From: mbrado@comcast.net
To: [Lauren Anderson](mailto:Lauren.Anderson)
Cc: [Lapan, Rosanne](mailto:Lapan.Rosanne); jpharnisch@comcast.net; surocook@mac.com; william.ellis2@comcast.net
Subject: File #DEV17-01
Date: Tuesday, February 21, 2017 8:21:02 AM

We live at 6 Eden Lane and are very concerned regarding the Velamoor variation petition.

FENCING PLAN

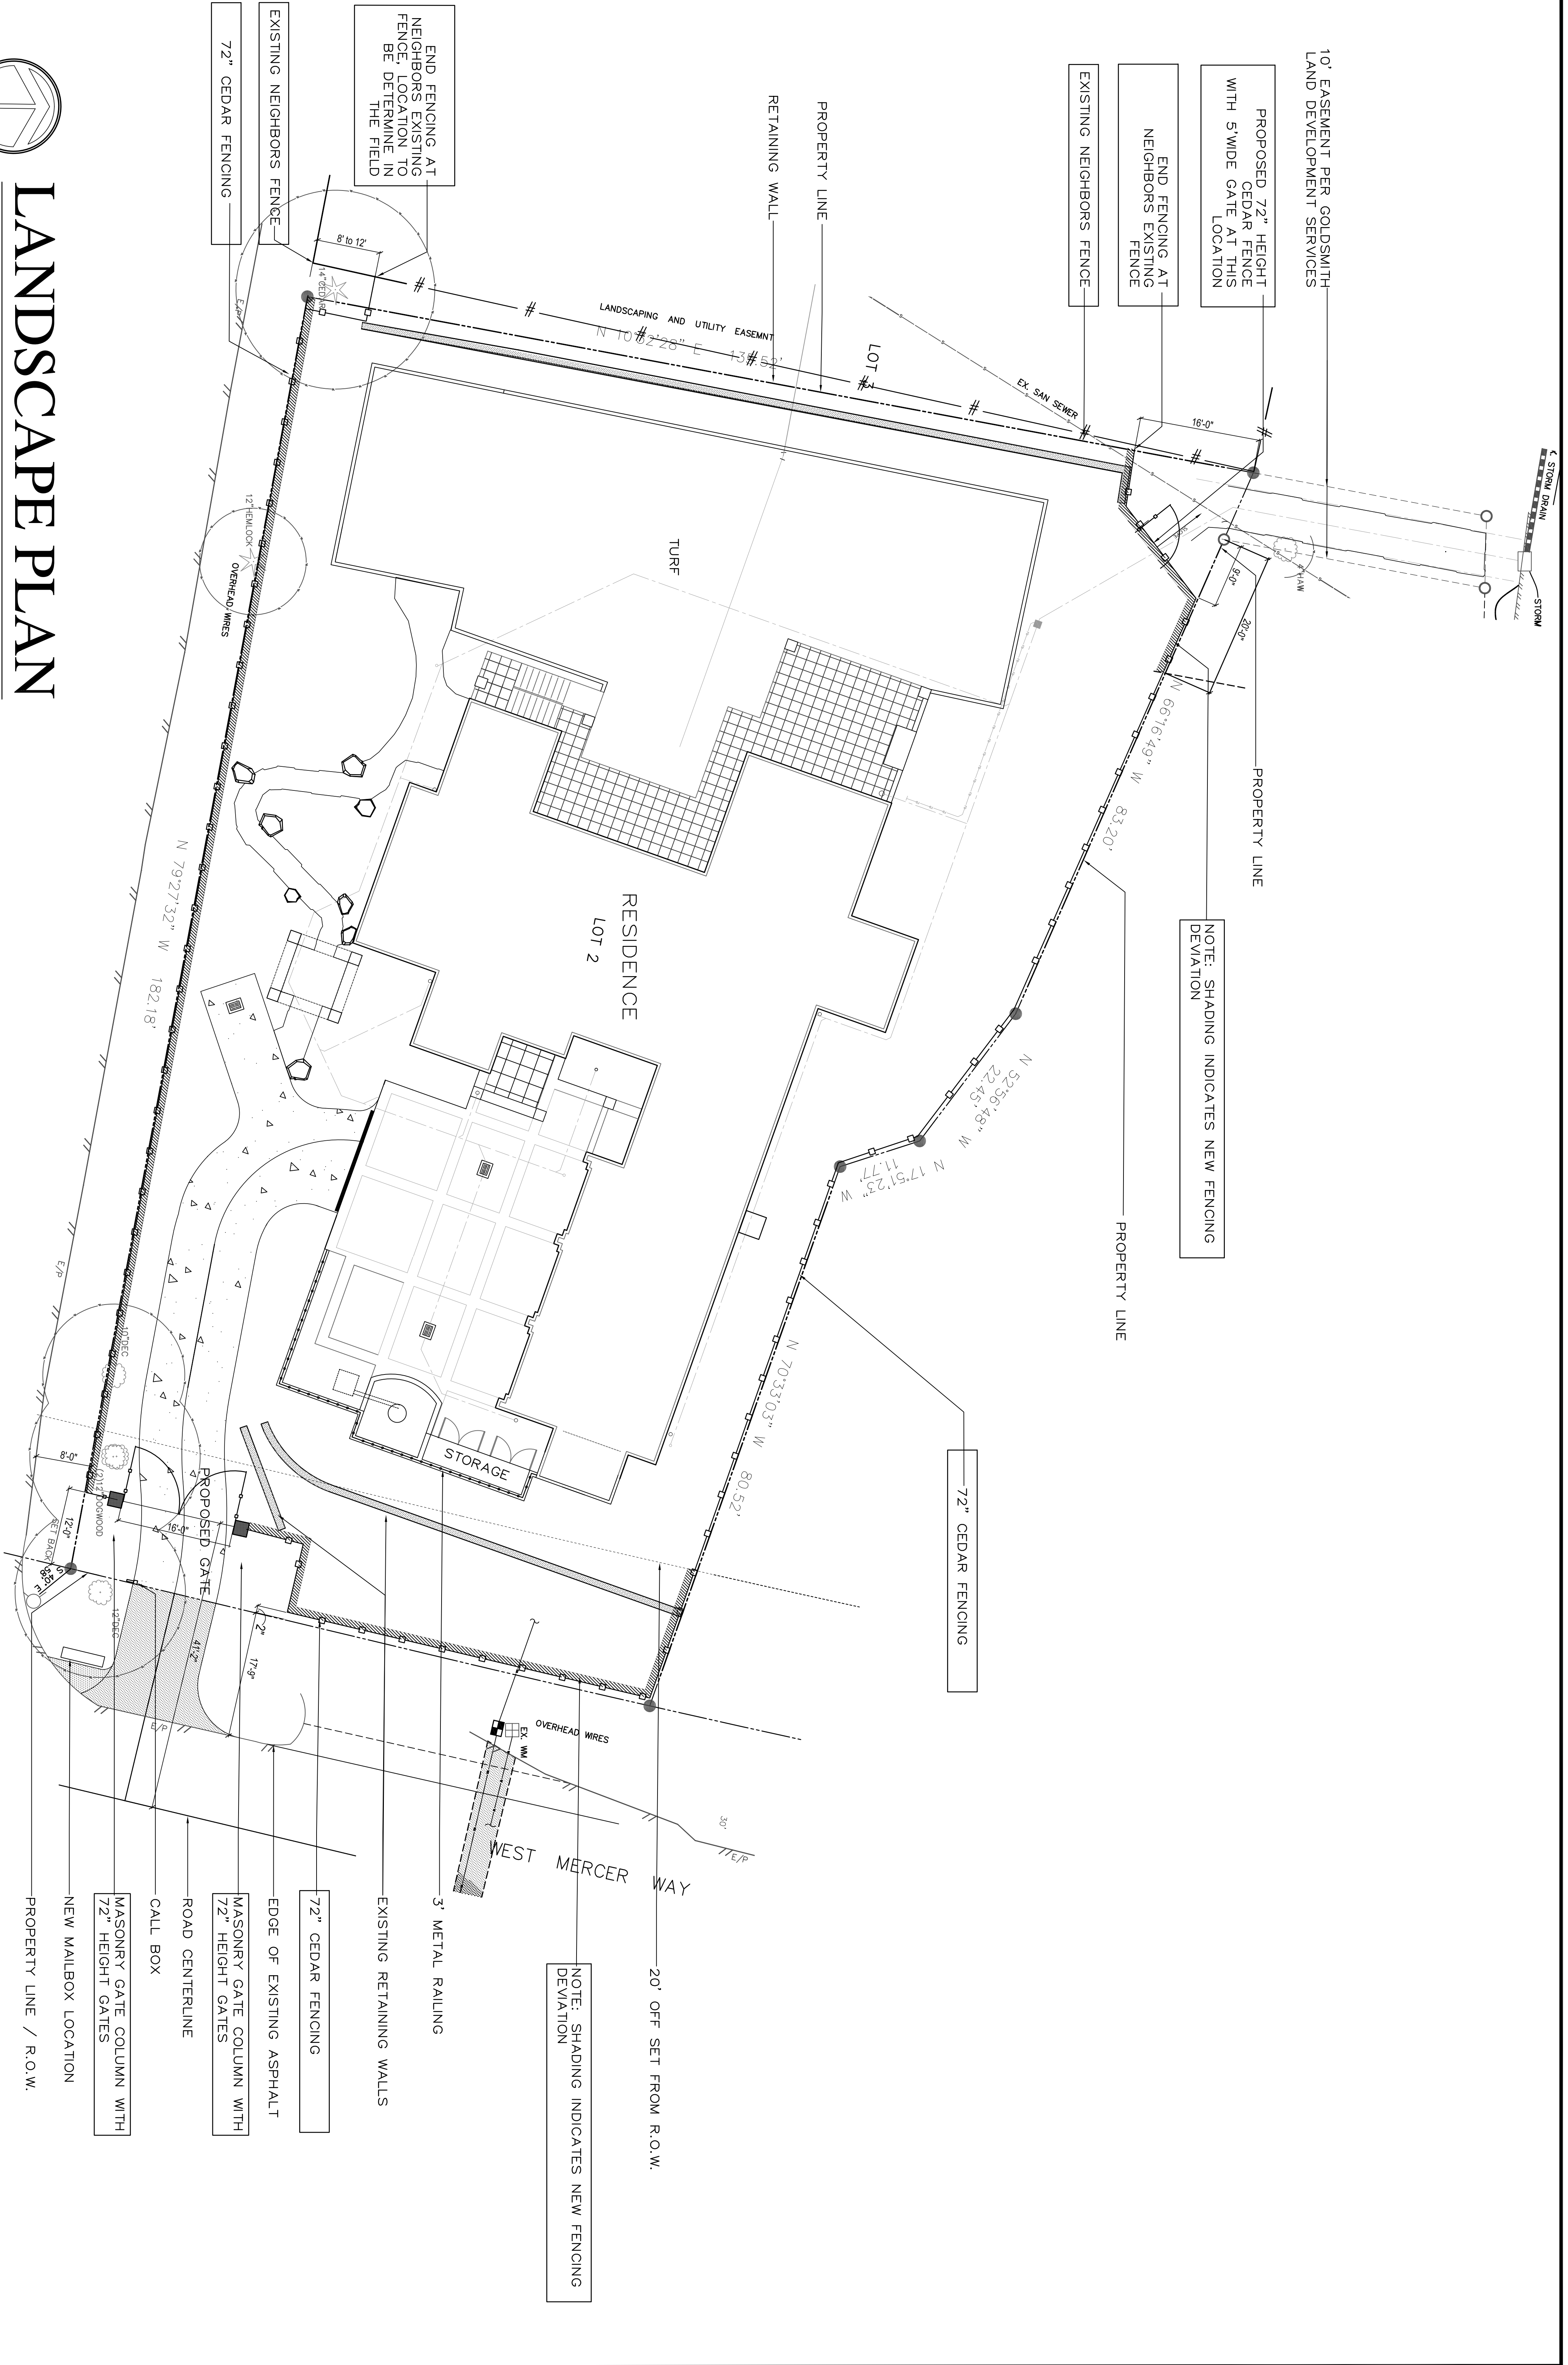
Firstly, the signage was not particularly obvious as construction workers' cars have been parked in front of the home constantly. We have had extreme difficulty exiting our lane for years now as these cars have obscured our view to West Mercer, already creating a hazard.

Perhaps too many trees were allowed to be removed initially. We can certainly understand Dr. Harnisch's very real concerns about the root structure of the few remaining trees if a fence/wall were to be installed.

A large fence makes us concerned that this would become a permanent hazard, but it would also be out of character with the area and the Island in general.

Finally, this also sets a precedent for the owner of 1 Eden Lane, and properties all over the island if this variance is approved. If this variance is approved the prospect of 1 Eden Lane following suit would create an even more dangerous situation with any one coming up Eden Lane trying to safely make it on to West Mercer heading in either direction.
